**REDEVELOPMENT OF SITE TO DELIVER EXTENSION TO EXISTING UNION PARK DATA CENTRE CAMPUS CONSISTING OF (A) FREE STANDING DATA CENTRE BUILDING (B) ENERGY, POWER, AND WATER INFRASTRUCTURE (C) SITE ACCESS AND INTERNAL ROADS (D) SITE SECURITY ARRANGEMENTS (E) HARD AND SOFT, GREEN LANDSCAPING AND (F) OTHER ANCILLARY AND AUXILIARY FORMS OF DEVELOPMENT (REF. 75111/APP/2025/739)**

Thank you for sharing the comments you have received to date regarding the above development. This response aims to provide clarity or additional information as needed with regards to urban design matters.

Landscape Masterplan

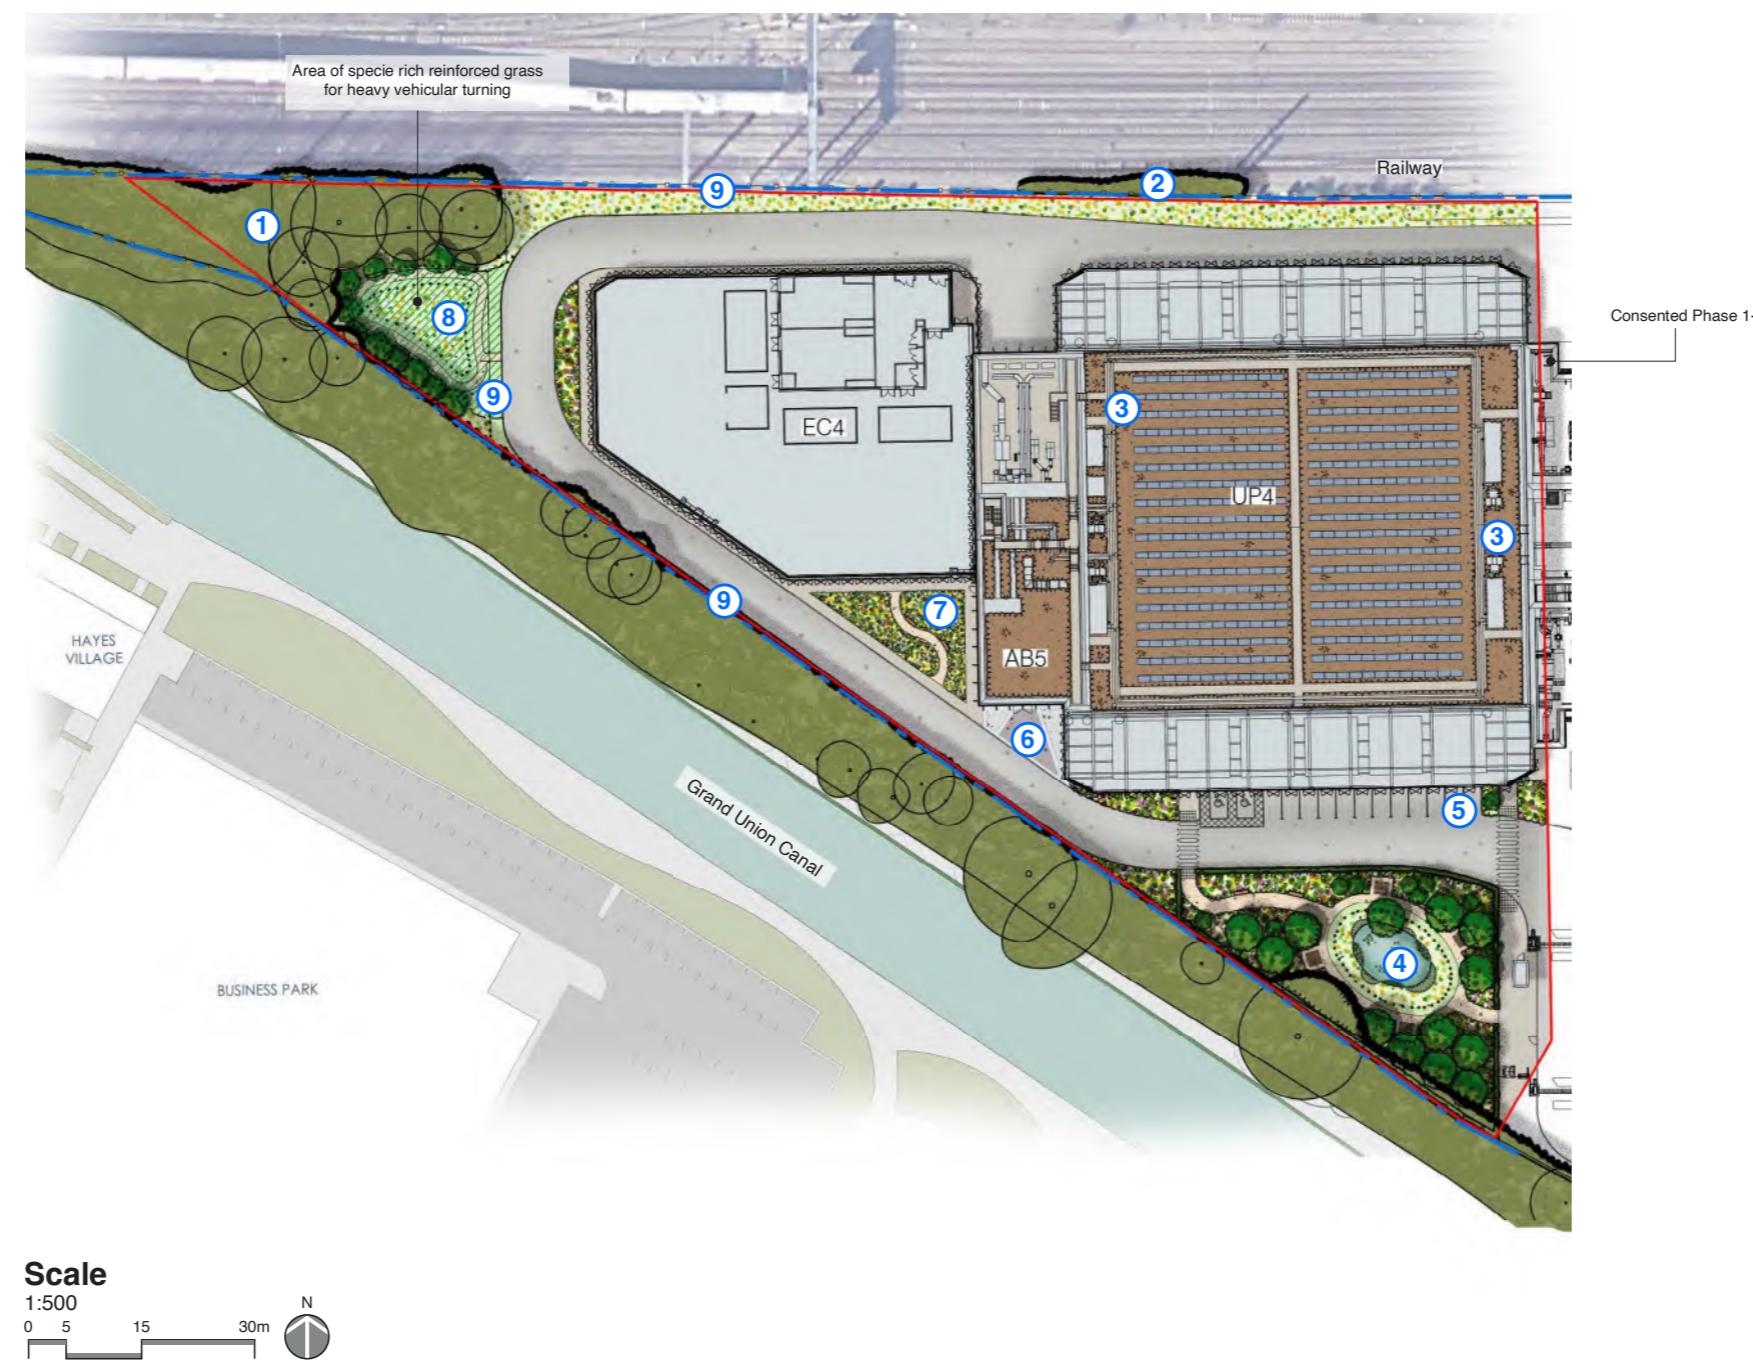
**2d. To provide clarification regarding the “species-rich reinforced grass” specification**

Attached to this letter is a *Block 4 Western Open Space* plan (ref. MWL-0474-SEW-ZZ-DR-L-100009 P3), which provides further details on the species-rich reinforced grass.

The plan shows the *Advanced Turf Reinforced Grass, Netlon Advanced Turf System* by Geosynthetics, but notes that something similar could be used is approved.

The Netlon Advanced Turf System (Netlon ATS) is a high-performance, mesh-reinforced natural grass rootzone system. It provides a visually appealing, SuDS-compliant, free-draining grass surface that can handle heavy vehicle loads in occasional-use scenarios. This system ensures a safe, wear-tolerant surface that resists compaction and rutting, supporting increased pedestrian and vehicle traffic, including heavy goods vehicles (HGVs), when paired with a suitable sub-base.

Additionally, the vehicle turning area with reinforced turf is only intended to be used by heavy vehicles for plant replacement, which is only expected to take place every 5 – 10 years. This area is otherwise framed with a gravel recreational path around the perimeter, scattered tree planting and timber benches to create a relaxing recreational space for staff.
